**KIRKLEES METROPOLITAN COUNCIL
INVESTMENT & REGENERATION SERVICE**

DELEGATED DECISION TO DETERMINE PLANNING APPLICATIONS

Reference No: 2018/62/90169/E

Site Address: Old Wine And Spirit Vaults, 42, Huddersfield Road,
Birstall, Batley, WF17 9AB

DRG:
PROPOSED ELEVATIONS

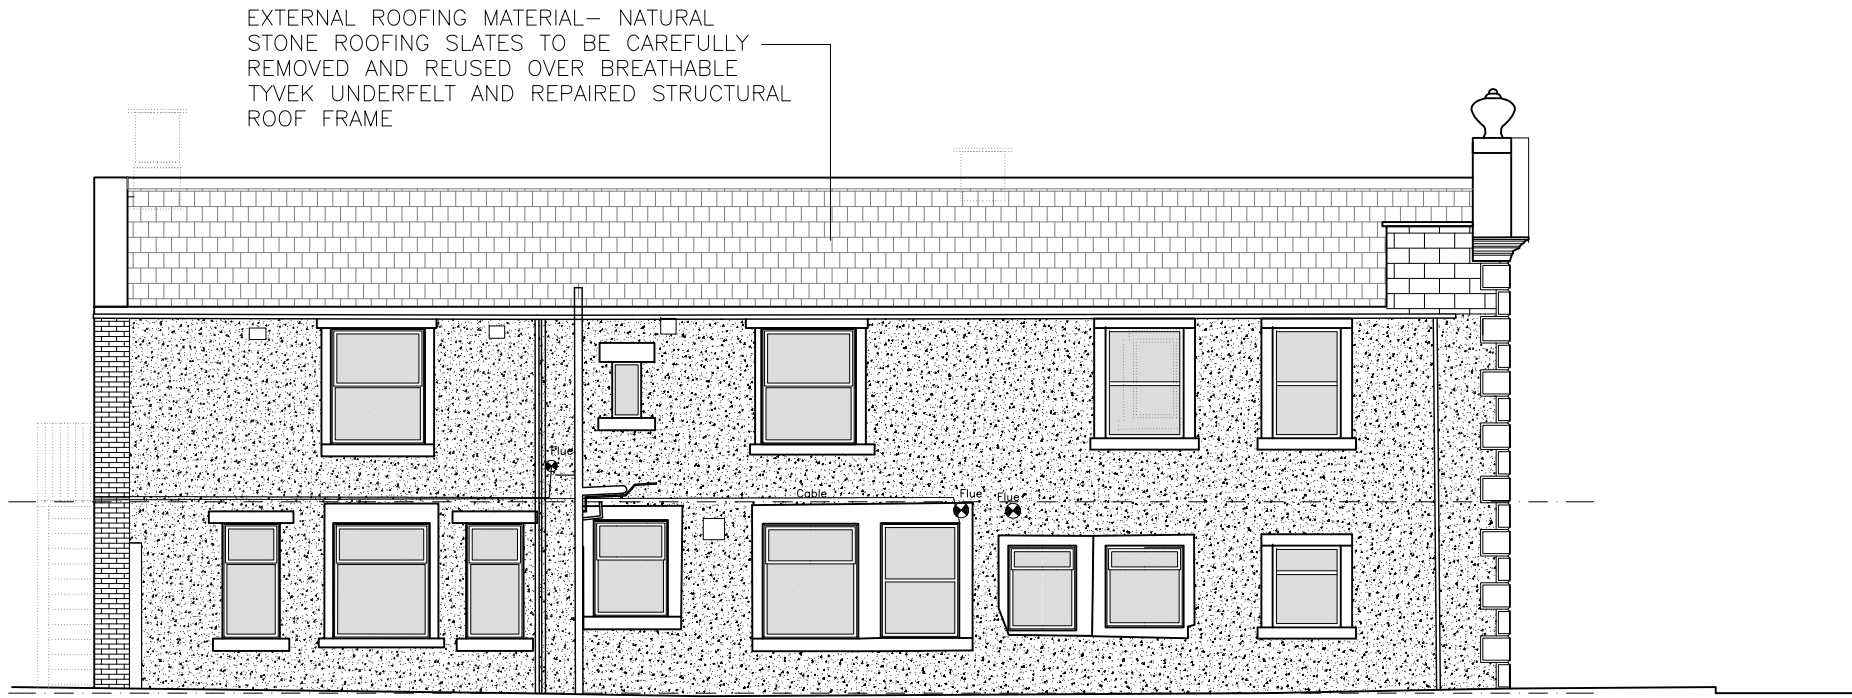
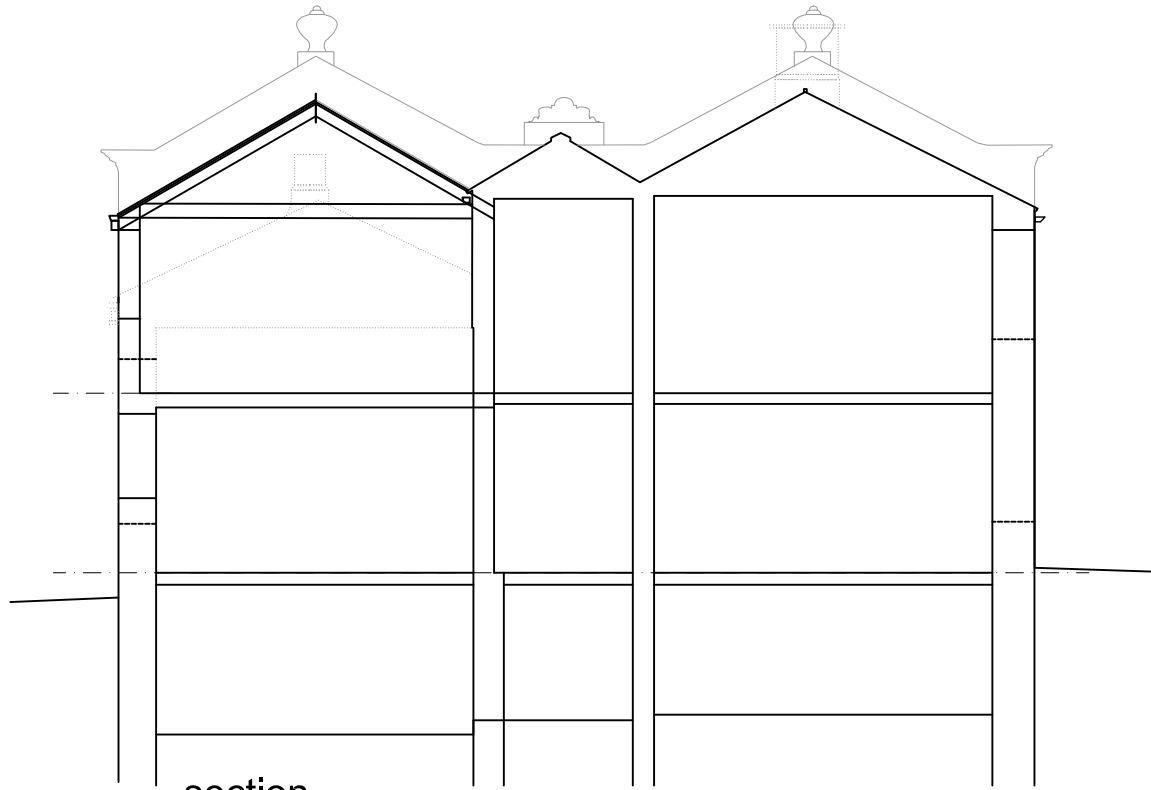
- The proposed conversion of this building is concerning due to its intention to substantially alter the north range and elevation of the building and destroy any evidence of the older 18th century cottages that form part of the building. This will result in the loss of an elevation identified as being positive within the Birstall Conservation Area Appraisal and will potentially lose the earliest extant entrance and layout of fenestration. The replacement and heavy handed modification of this elevation should therefore be avoided at all costs. There is also no structural evidence provided that would necessitate the demolition of this whole elevation and a structural survey by an accredited heritage surveyor should be sought before any approval is given as there will likely be another solution to this problem.

The main concern was with regard to the proposed substantial rebuilding works to the north elevation, which is an elevation that has been identified within the Birstall Conservation Area Appraisal as contributing in a positive manner to the significance of the conservation area. With this elevation having been identified as being of significance, any works to it must be justified and fundamentally contribute to the preservation or enhancement of the character or appearance of the area. Within the supporting information it was noted that this work was proposed as a result of a structural defect, however this was not supported by a structural survey, nor had it been demonstrated that the works are the minimum measures necessary to resolve the defect. Demolition of this elevation would have destroyed all evidence of the early extant entrance and historical fenestration arrangement, and would only be considered if all efforts to retain the structure have been exhausted. The severity of the works and the resultant loss of features of architectural significance would have resulted in harm which would not have been outweighed by the limited public benefit which would arise.

6. The first floor extension shall be constructed of natural stone and stone slates. Any replacement roofing slates shall match the existing in terms of type, colour and texture.
Reason: In the interests of conserving and enhancing the Birstall Conservation Area and to accord with Policy BE5 of the Kirklees Unitary Development Plan, Policy PLP35 of the Kirklees Publication Draft Local Plan and Chapter 12 of the National Planning Policy Framework.

8. Any new rendering works to the North elevation of the building shall be completed in accordance with details that have previously been approved in writing by the Local Planning Authority.
Reason: In the interests of conserving and enhancing the Birstall Conservation Area and to accord with Policy BE5 of the Kirklees Unitary Development Plan, Policy PLP35 of the Kirklees Publication Draft Local Plan and Chapter 12 of the National Planning Policy Framework.

9. All new guttering shall be of timber construction and all down pipes of aluminium construction. All new vents shall have a black colouring.
Reason: In the interests of conserving and enhancing the Birstall Conservation Area and to accord with Policy BE5 of the Kirklees Unitary Development Plan, Policy PLP35 of the Kirklees Publication Draft Local Plan and Chapter 12 of the National Planning Policy Framework.

In response to these concerns, amended plans have been received which now propose to retain the northern elevation of the building. Conservation and Design consider the revised plans now address their previous concerns and raise no further objections. Conditions are suggested to ensure any new roofing materials and window surrounds match those existing, that details of any replacement render to the northern elevation are first approved, and that new any new gutting is timber, fall pipes are aluminium and vents are black. The amended proposal would preserve the character and appearance of the Birstall Conservation Area and would accord with UDP policy BE5, PLP35 of the emerging Local Plan and paragraph 137 of the NPPF.
